# Rezoning Transportation Analysis

Petition Number: 2023-070

## Revision Log:

Date	Description
9-28-23	First Review (TM)
03-20-23	Second Review (TM)

SITE PLAN
 NEIGHBORHOOD COMMERCIAL CENTER

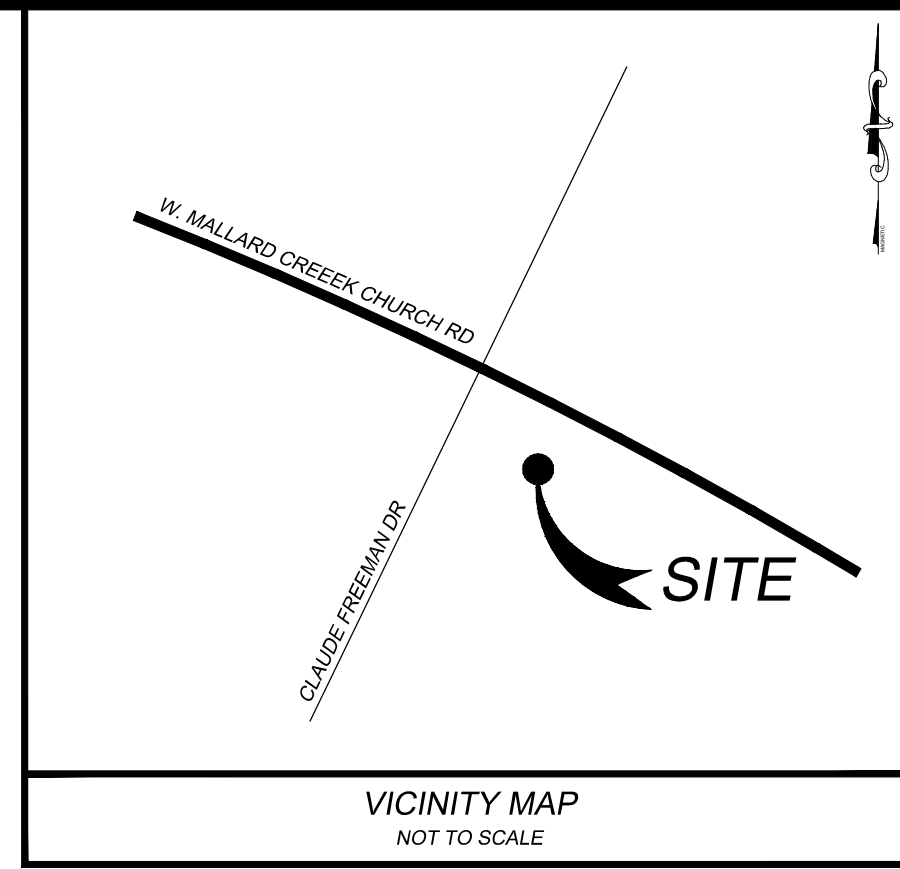
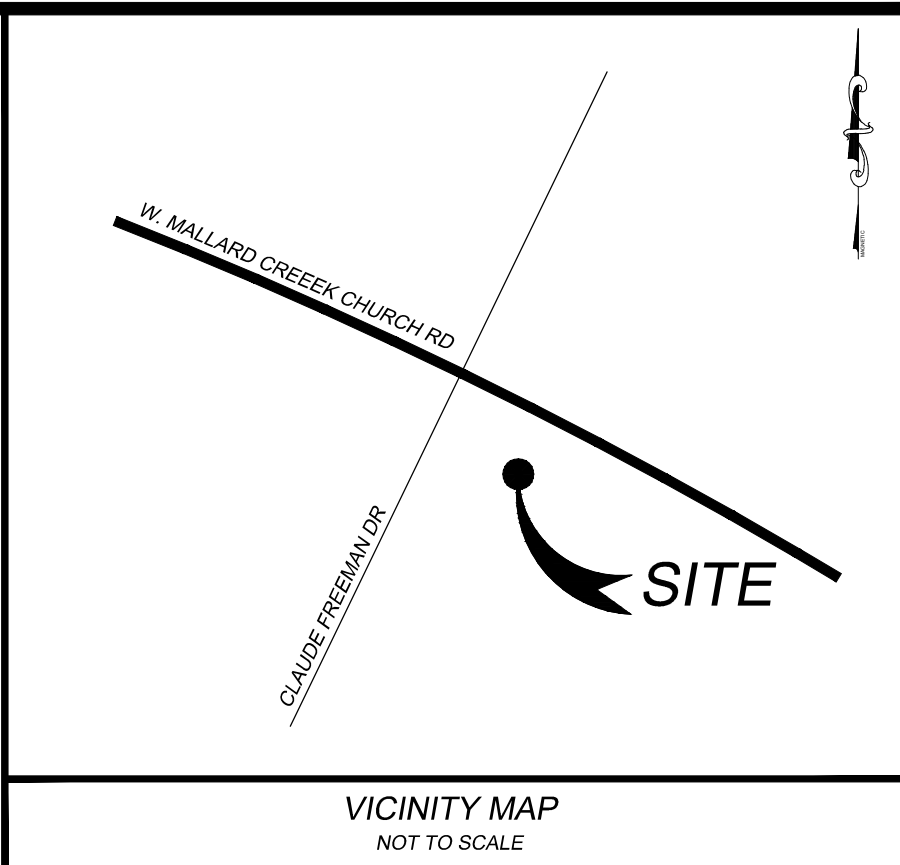
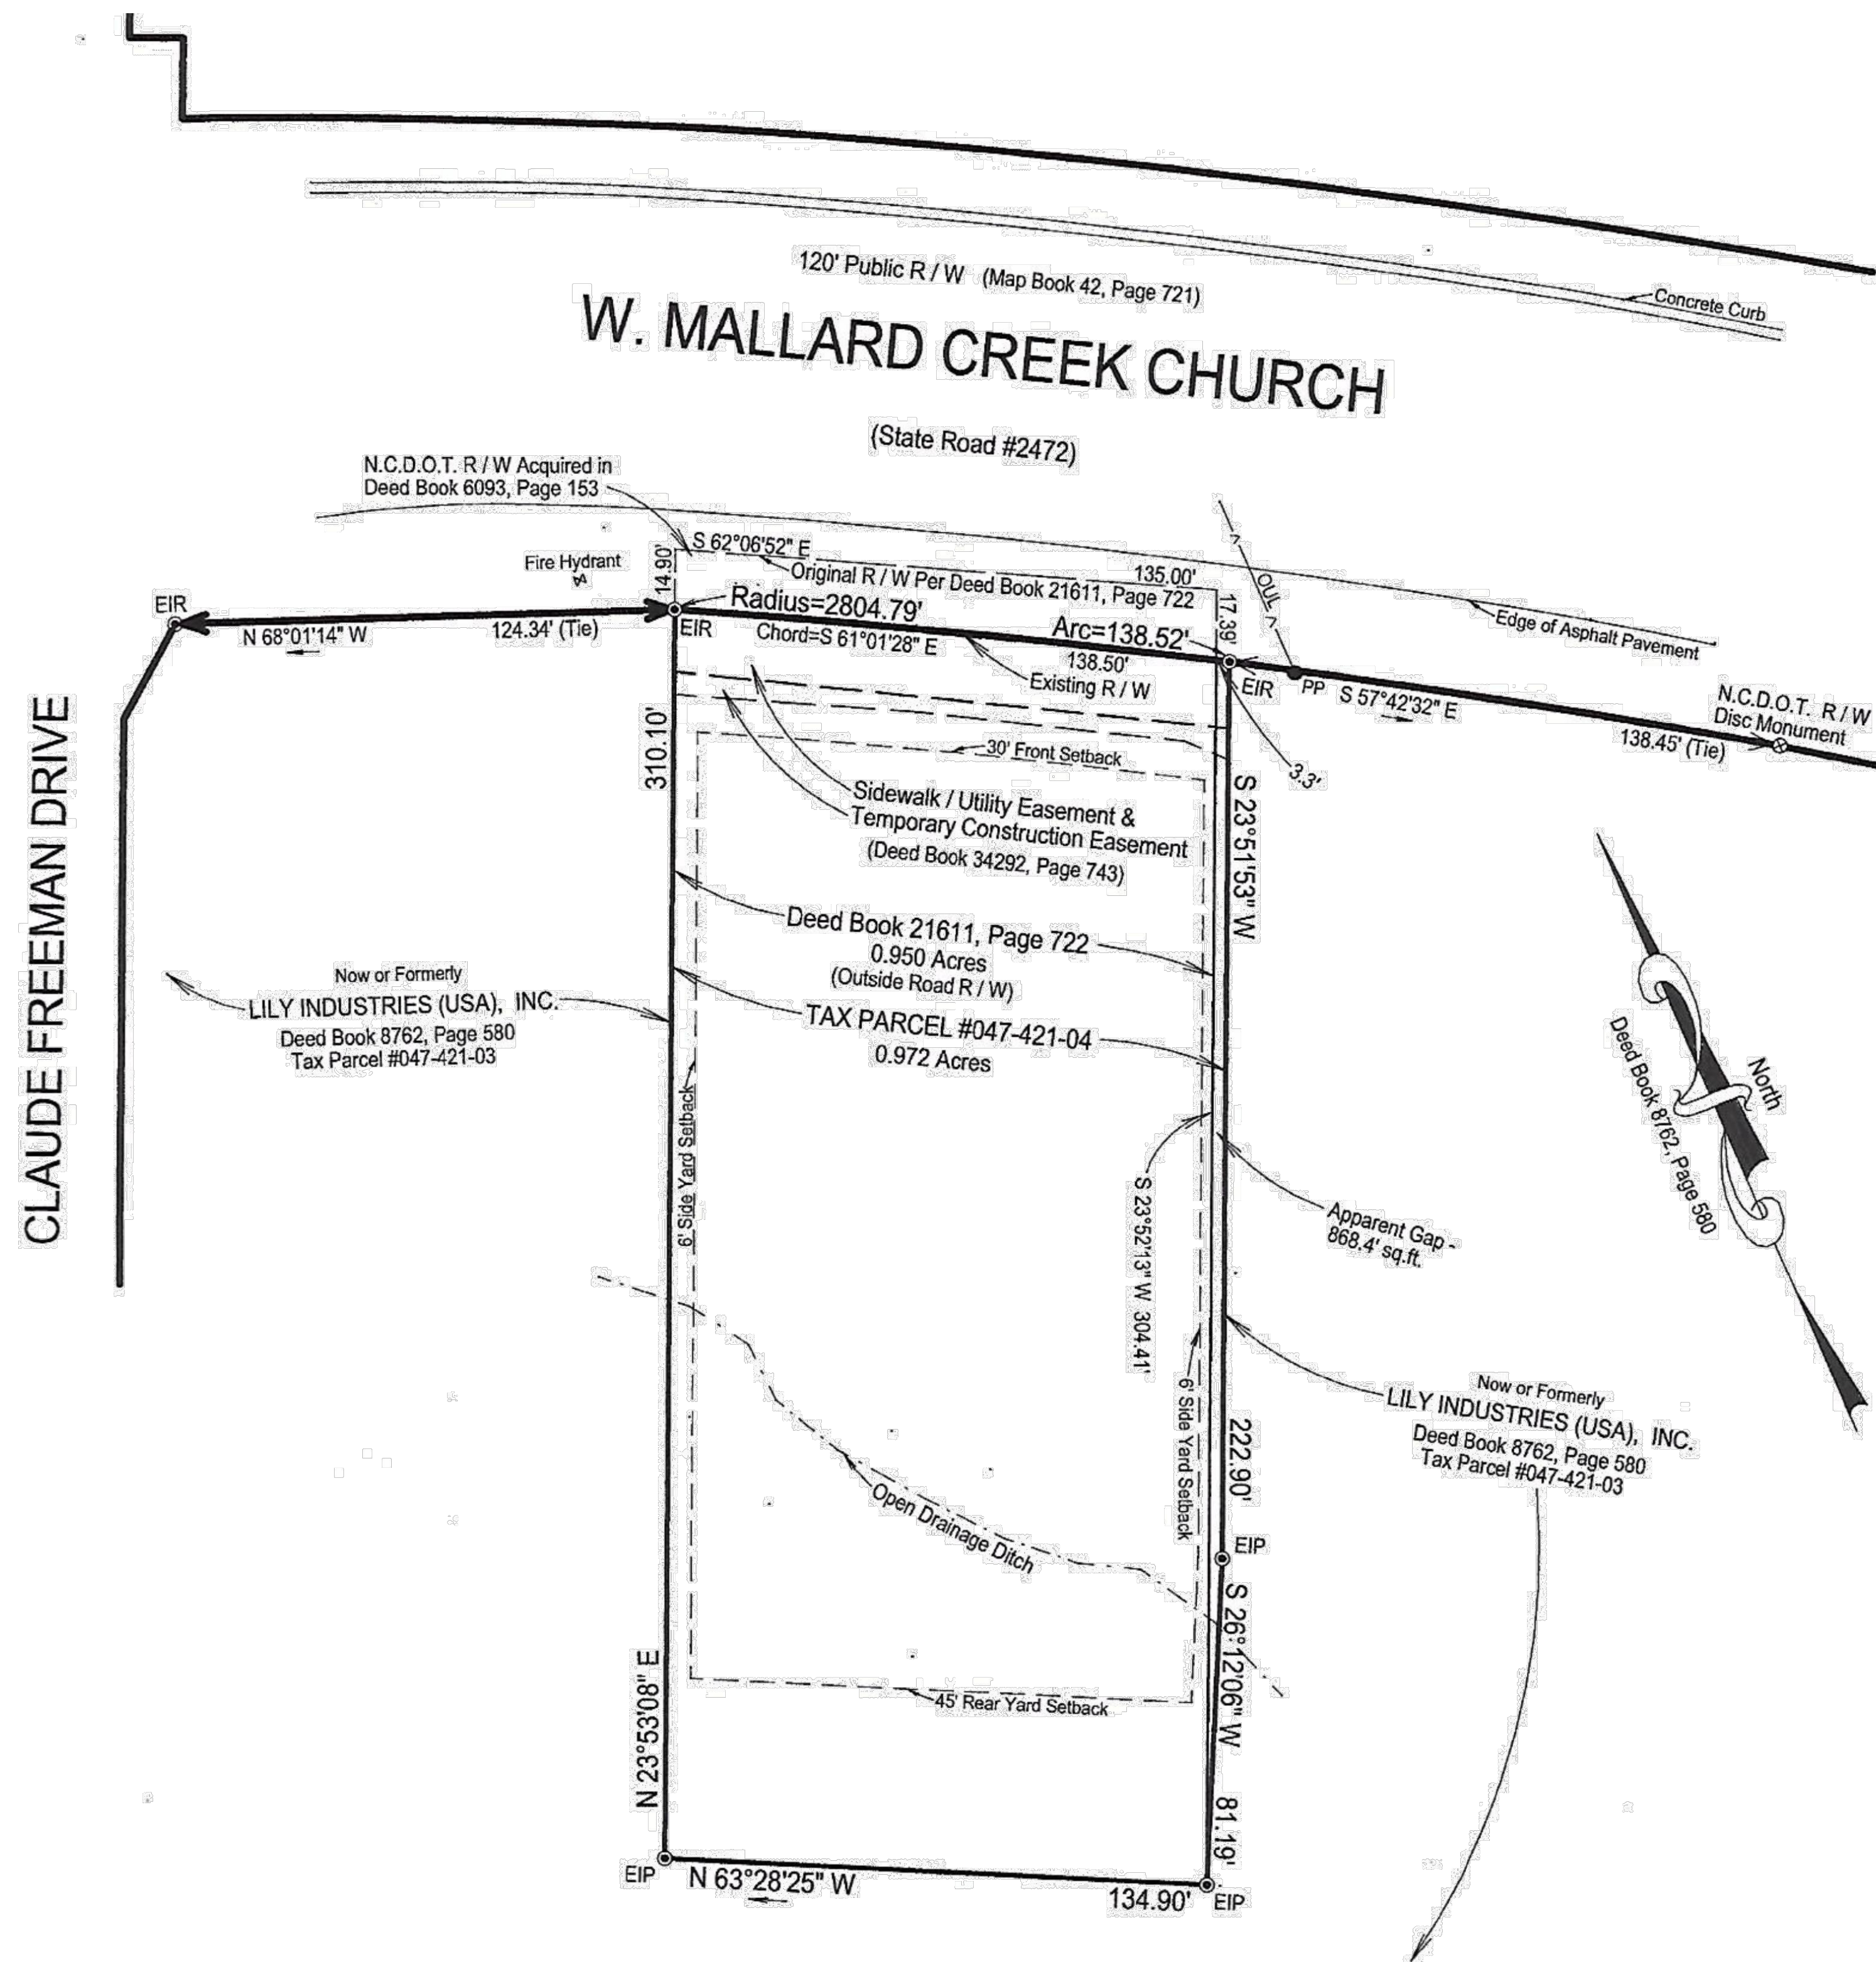
**Outstanding CDOT Issue From 09-28-23: Mallard Creek Church Road:** Location of curb and gutter is to be constructed at 33-feet from roadway centerline.

Label and dimension the curb and gutter from the centerline for each road on the site plan.

**3. Outstanding CDOT Issue From 09-28-23:** Revise site plan and conditional note(s) to commit to dedicate 50-feet of right-of-way from the road centerline. The site plan shall label and dimension the right-of-way from the road centerline.

4. Revise site plan and conditional note(s) to commit to cross-access to both adjacent parcels to meet minimum UDO requirements regarding parcel access in Chapter 31.2 of the UDO.

**Outstanding CDOT REQUESTS from 09-28-23:** Cross-access is required to both adjacent parcels, to be constructed to the property line. CDOT requests that the petitioner add sidewalk accommodations at both cross-access locations to promote future pedestrian connectivity.

5. **Outstanding CDOT Issue From 09-28-23:** Revise site plan and conditional note(s) to commit to providing a 50-foot driveway stem measured from the edge of pavement along Mallard Creek Church Road in coordination with NCDOT.
6. **Outstanding CDOT Issue From 09-28-23:** Revise site plan and conditional note(s) to commit to removing the raised pork chop median from site plan access on Mallard Creek Church Road. Mallard Creek Church Road is currently a right in right out due to the existing median.
